OBSERVATION/SUBMISSION TO PLANNING APPLICATION

Case Reference: 324113

Re: Observation to the proposed development of open-cycle gas turbine (OCGT) and generator with ancillary equipment.

Location: Pollnagroagh and Rathmorrissy (Townlands), Athenry, Co. Galway

Purpose		PLANNING			
Title		SITE ACCESS SIGHTLINES			
Original Scale	Design/Drawn	Checked	Authorised		
SHOWN at A1	PS	ND	AJB		
Date	Date	Date	Date		
01.12.25	01.12.25	01.12.25	01.12.25		
Status	Drawing Number	Rev			
A2	PEK3-ATK-ZZ-01-DR-CE-901200	0

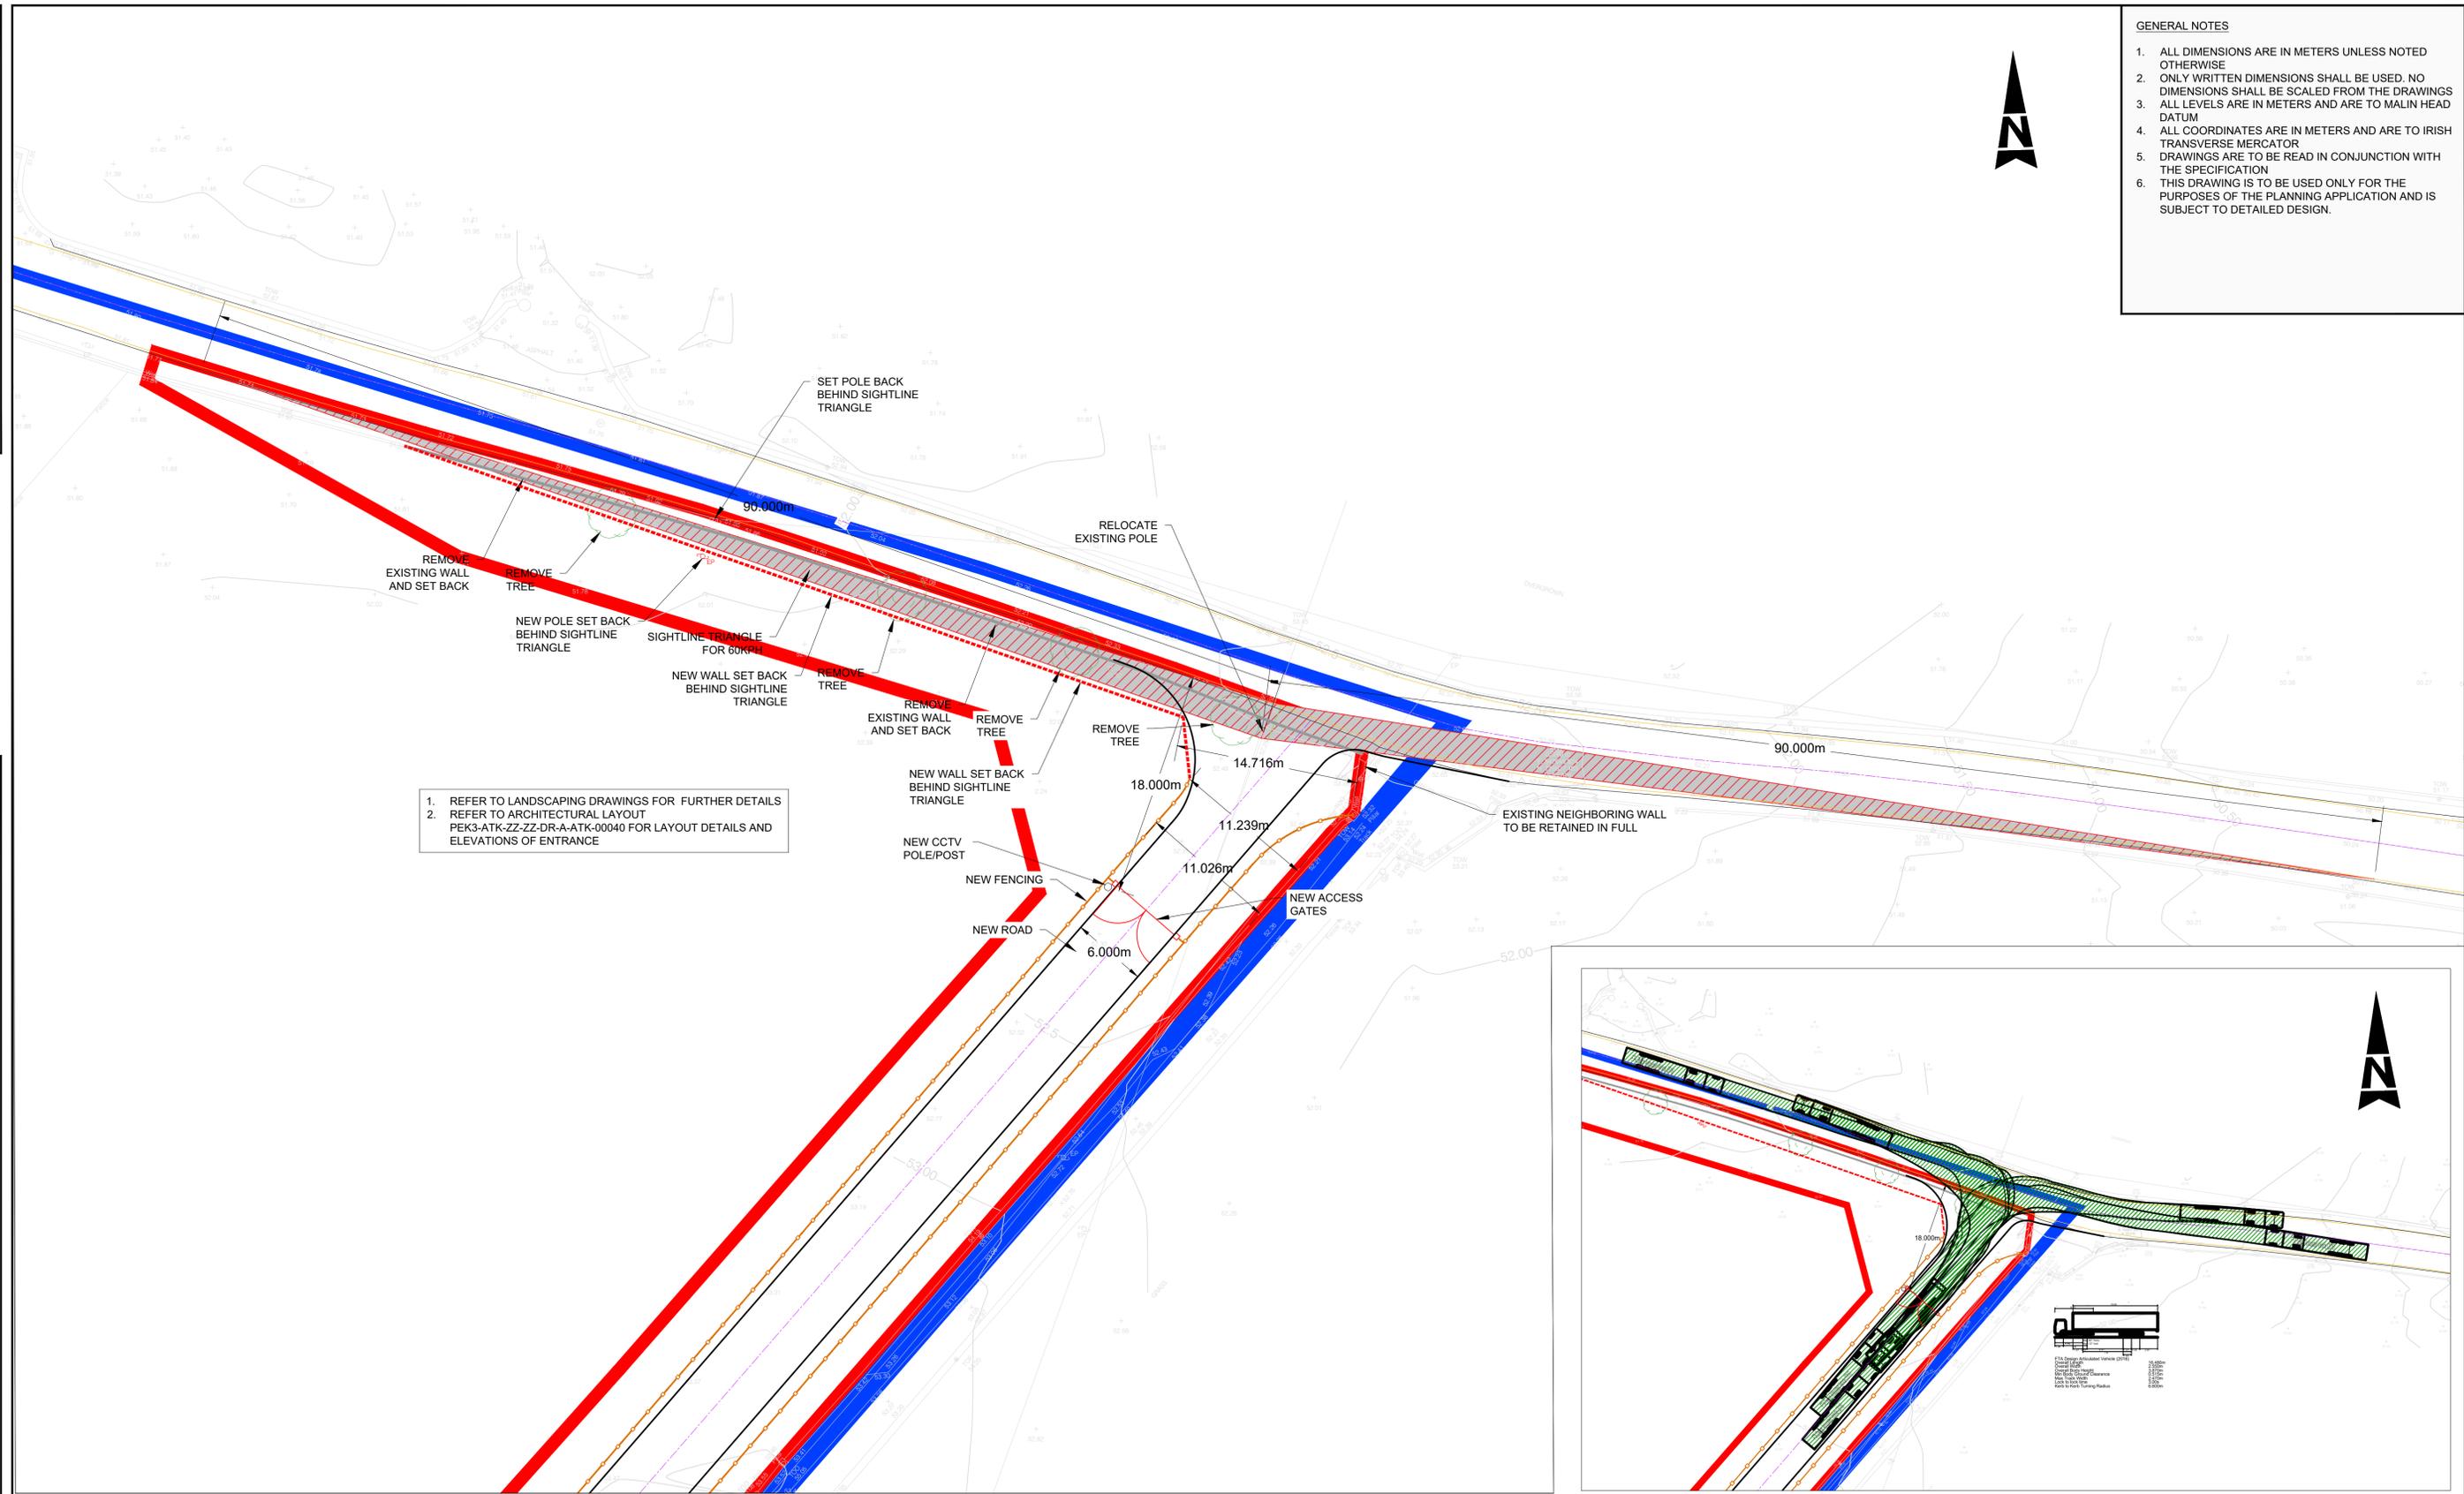
The placement of the proposed site entrance on the L3103 raises severe safety concerns due to the inherently hazardous nature of this specific stretch of road. The carriageway is critically narrow, struggling to safely accommodate two passing Heavy Goods Vehicles (HGVs), and completely lacks a hard shoulder to allow for any margin of error. Compounding these dangers are the presence of blind dips and corners, which significantly reduce visibility and sightlines for all road users. These critical safety deficiencies create an unacceptable traffic hazard that must be comprehensively addressed.

Positioning the site entrance at this location on the L3103 introduces extreme risk to road users. This treacherous section of the road is entirely devoid of a hard shoulder and is physically too narrow for two HGVs to pass one another safely. Furthermore, severely compromised sightlines caused by blind dips and sharp corners make this access point highly perilous. It is imperative that these severe, compounding traffic hazards are urgently mitigated before any development is permitted.

The proposed site entrance is located on an exceptionally dangerous section of the L3103. Establishing an access point at this specific location introduces an unacceptable level of risk due to several compounding hazards:

- Severely Restricted Width: The road is currently too narrow to safely permit two Heavy Goods Vehicles to pass simultaneously.
- Absence of a Hard Shoulder: There is no safe refuge or margin for error for manoeuvring vehicles.
- Critically Poor Visibility: The immediate area is affected by blind dips and blind corners, severely compromising driver sightlines.

The placement of a site entrance at this hazardous location on the L3103 introduces significant and clearly identifiable safety risks, including restricted road width, lack of a hard shoulder, and severely limited visibility due to blind dips and corners. Despite these known constraints, the Environmental Impact Assessment does not adequately assess the safety implications of this access point.
